**From:** [REDACTED]  
**Sent:** 21 May 2026 22:44  
**To:** Neil Crowther  
**Cc:** Karl Roberts; Dawn Hudd; Beccy Cooper MP; Paul Cann  
**Subject:** A/44/26/PL (BC11823)

DRAINAGE (SHEET 1)

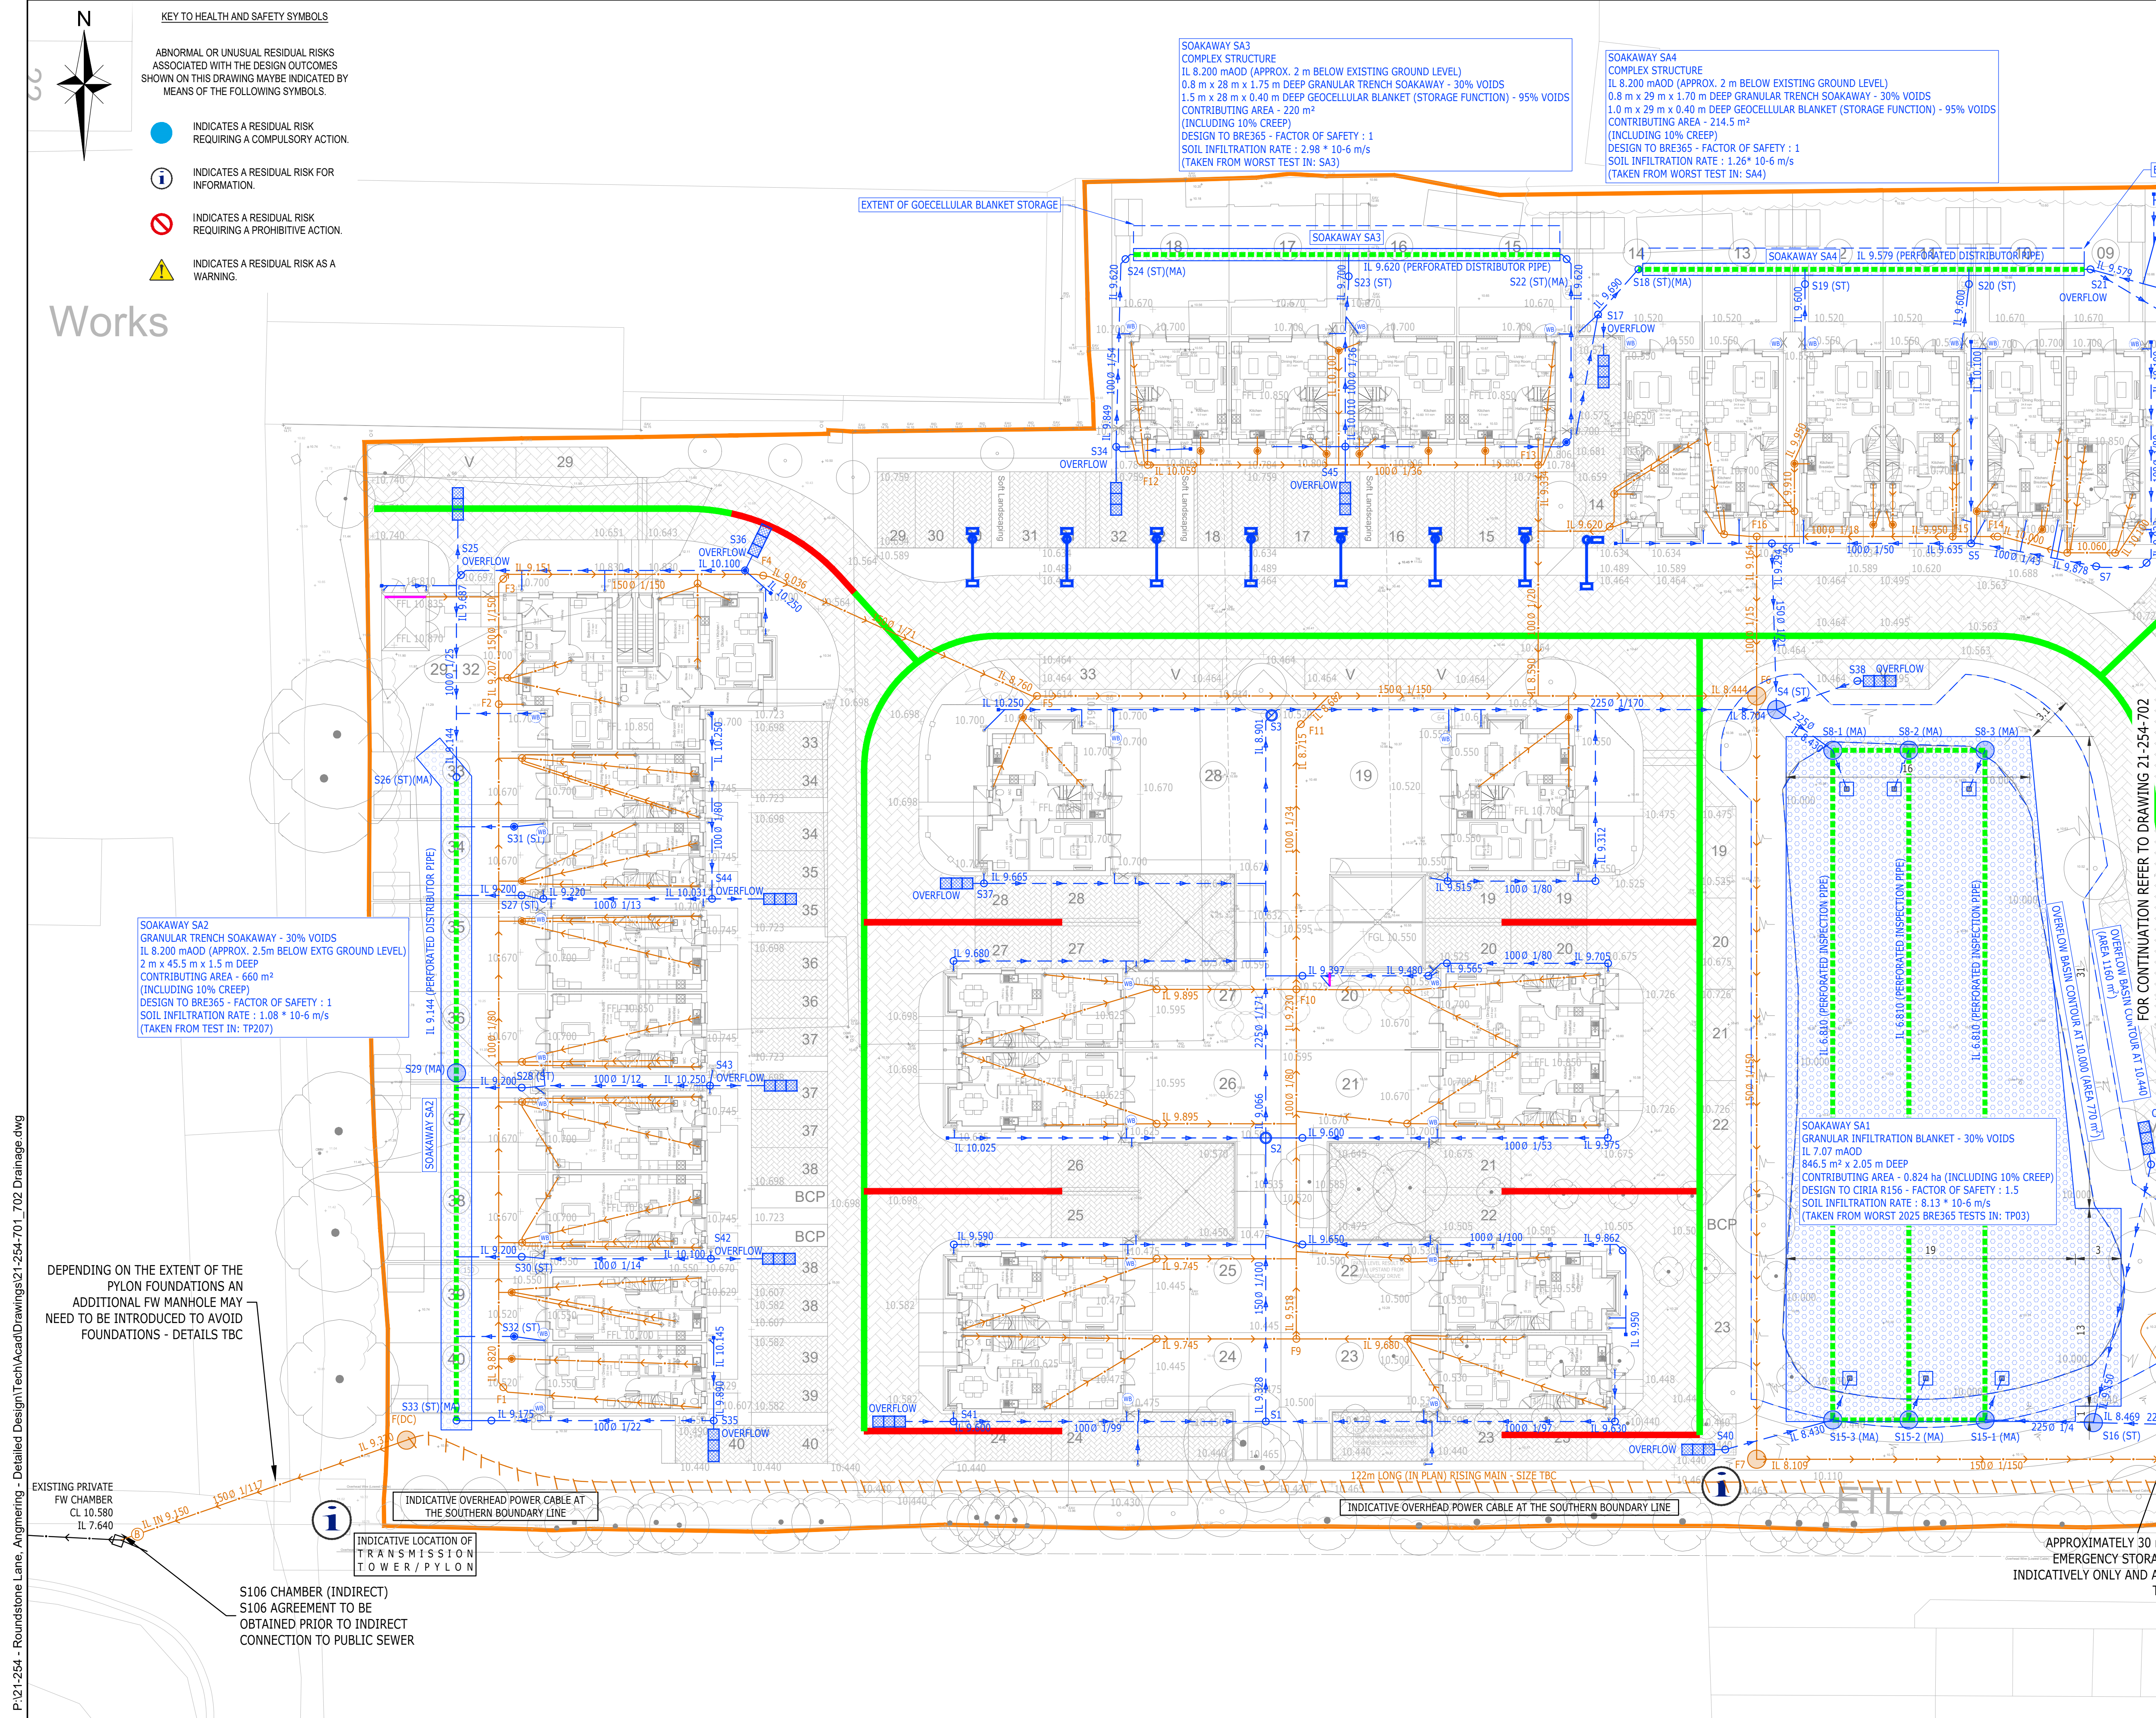
Application A/115/25/PL contained infiltration testing for SA1 which was carried out in April 2025, and this application was rejected. In the officer's report it is stated that one of the reasons was "*Adequate winter infiltration testing has not been supplied.*"

This same infiltration testing data has been used again for application A/44/26/PL.

This states very clearly that winter testing is preferred and encouraged, unless it can be proven that the worst case happens outside of this period. By the applicant’s own testing, submitted with this application, the “*worst case design conditions*” have been proven to be February when the high groundwater level peaked. This should therefore be determinative of the question whether April 2025 testing can properly be treated as representative of worst-case design conditions. That issue is material because A/115/25/PL was refused on the basis that adequate winter infiltration testing had not been supplied. It is also material because Condition 28 of the original permission A/64/21/PL expressly required “*winter Percolation testing to BRE 365*”, and there appear to have been no subsequent updates to any relevant national standard which depart from, dilute, or supersede that requirement. That testing should have been carried out as a pre-commencement requirement, before any dwellings were constructed.

In light of the refusal reason on A/115/25/PL, the wording of Condition 28 on A/64/21/PL, ADC’s current infiltration-testing guidance, and the applicant’s own groundwater monitoring showing February as the relevant high-groundwater period, please could ADC explain the basis upon which April 2025 infiltration testing now appears to be considered adequate for A/44/26/PL, if that is ADC’s position?
